FIVE
ESTUARIES
OFFSHORE WIND FARM

10.7 NOTIFICATION OF INTENTION TO
SUBMIT A CHANGE REQUEST

Application Reference:	EN010115
Document Number:	10.7
Revision:	A
Pursuant to:	Planning Act 2008 – Section 89(3)
Eco-Doc Number:	005337387-01
Date:	September 2024

EN010115 Five Estuaries Offshore Wind Farm – Notification of Intention to Submit a Change Request

DRAWING NUMBER: **005023882-01**
 APFP Regulation: 5(2)(a)
 Sheet No: 12 of 20

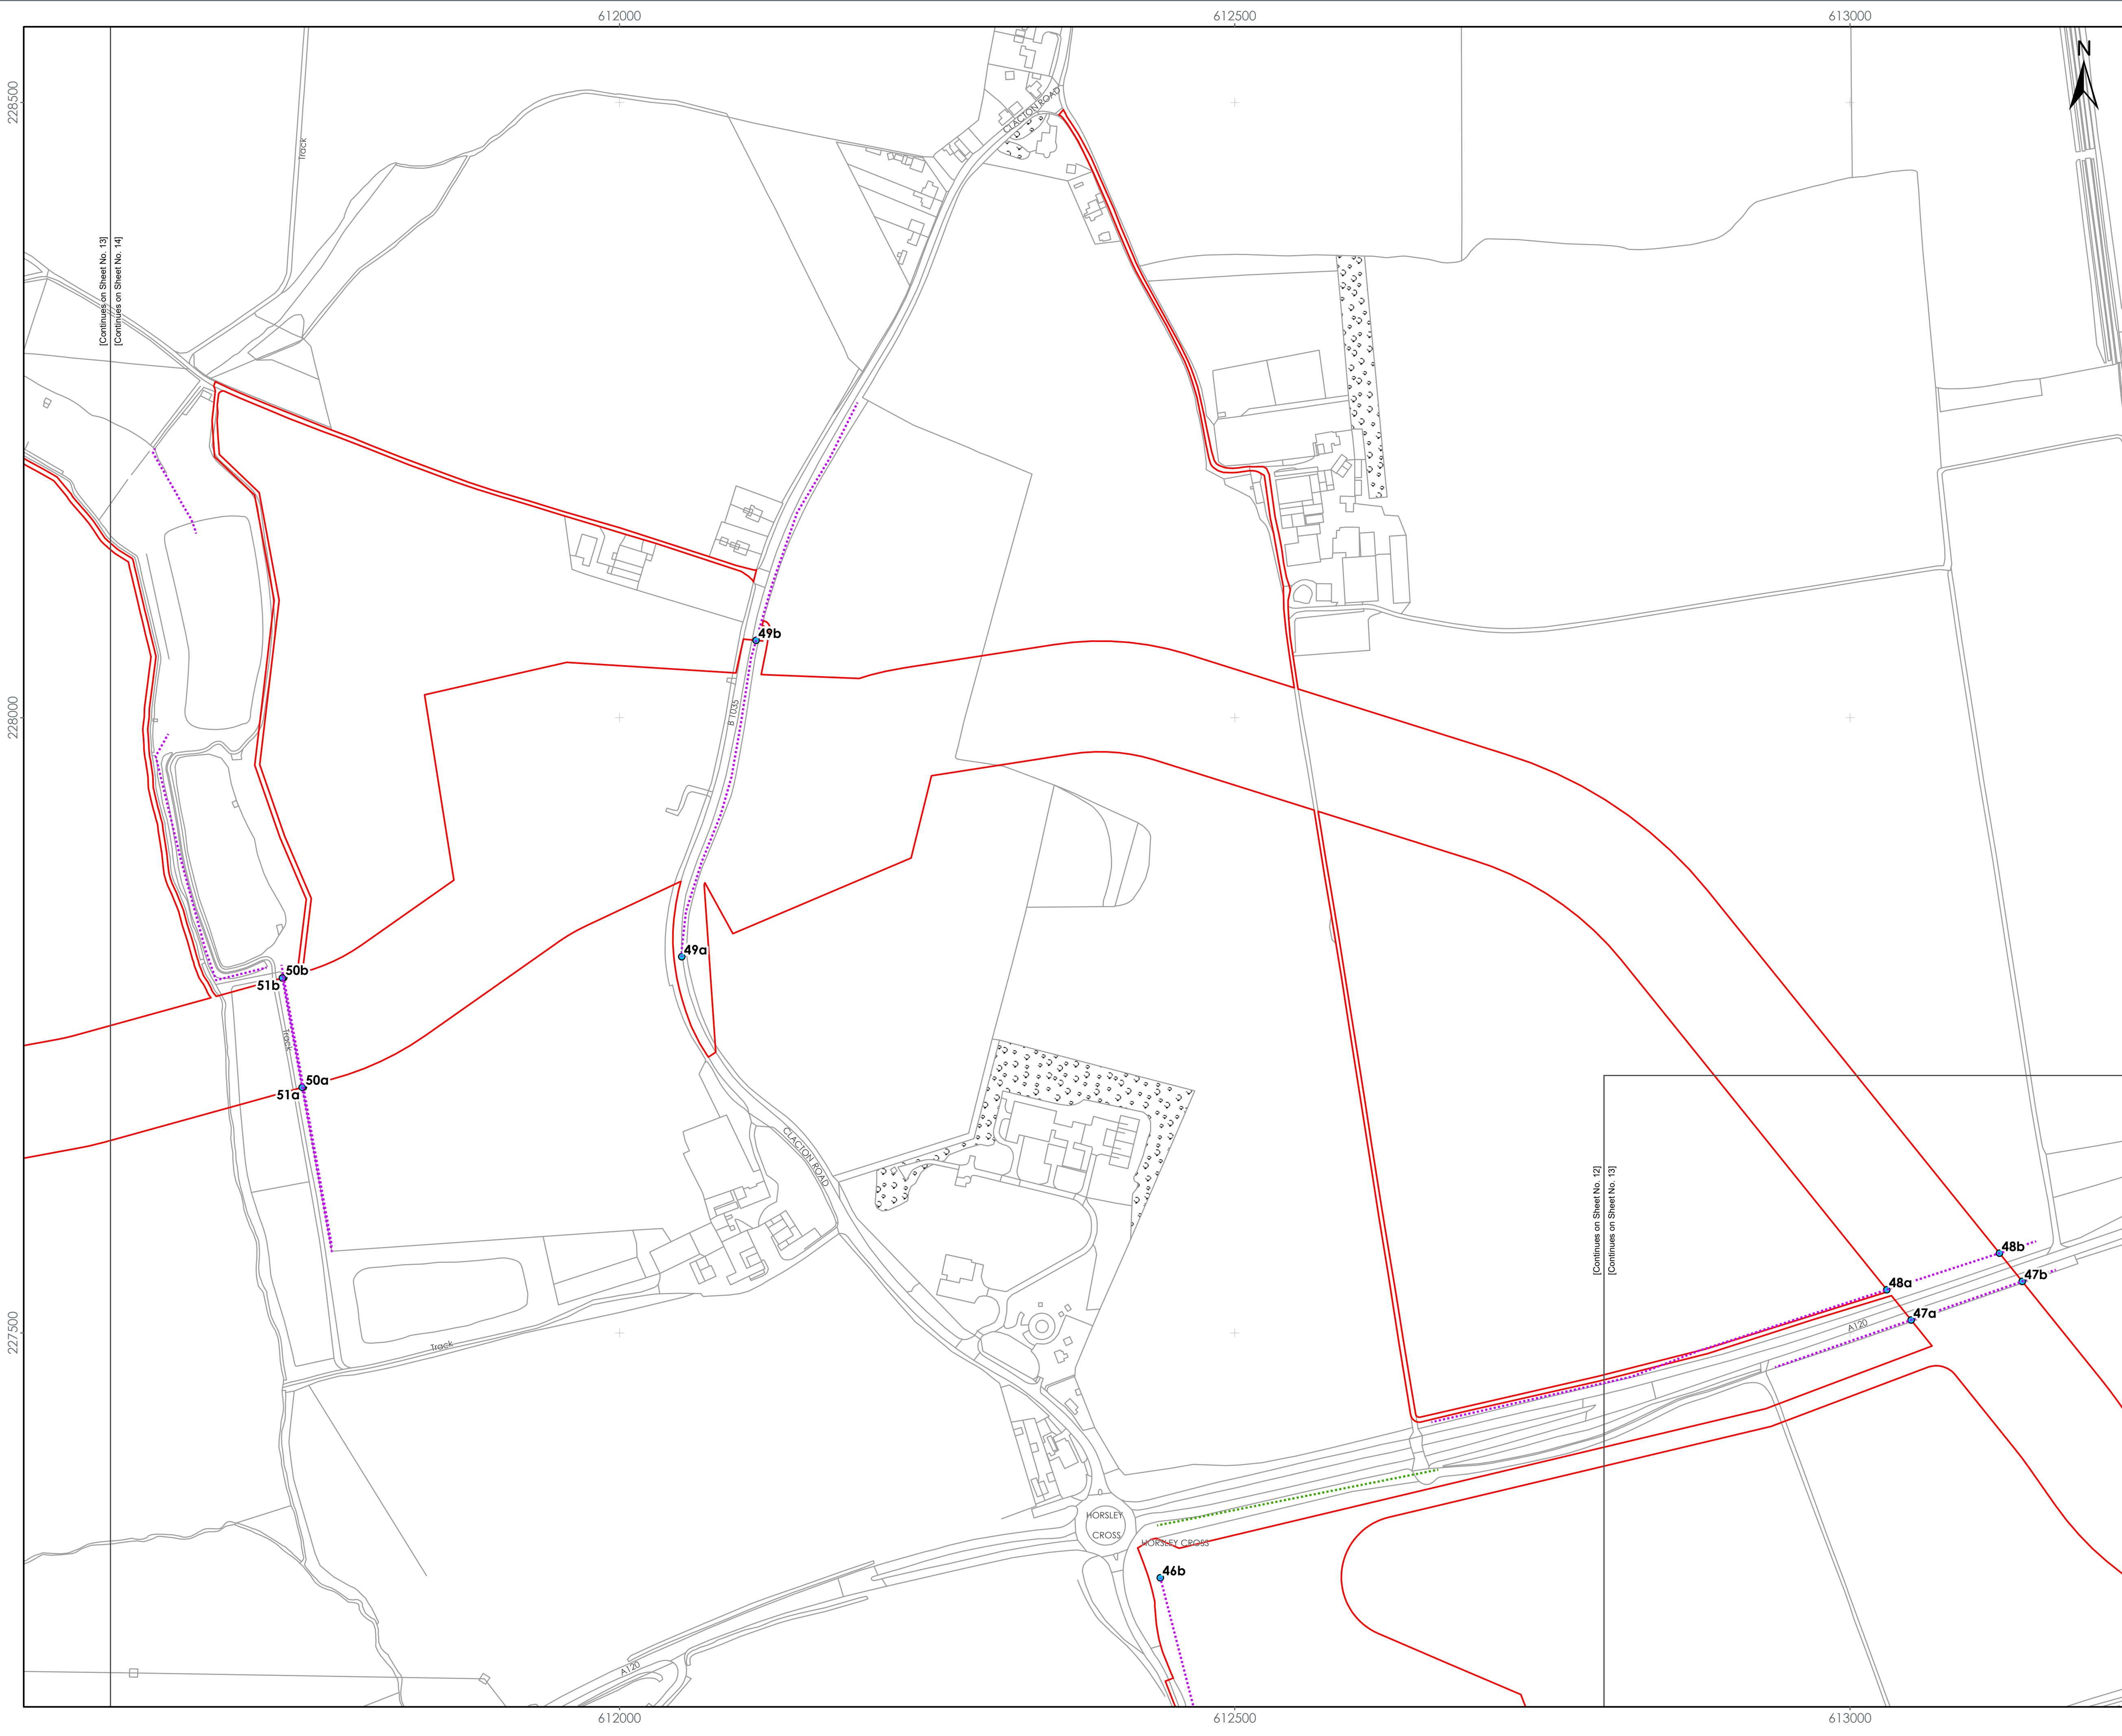
2.8.1 The powers to impact trees with existing Tree Preservations Orders (TPO) were not included in the dDCO [APP-024]. The TPOs are shown on 2.10 Tree Preservation Order and Hedgerow Plan [APP-015] Sheet 12 of 20.

2.8.3 The dDCO will be updated to include amended wording to cover the need to authorise works to protected trees and a new part in the schedule listing the relevant orders and trees affected.
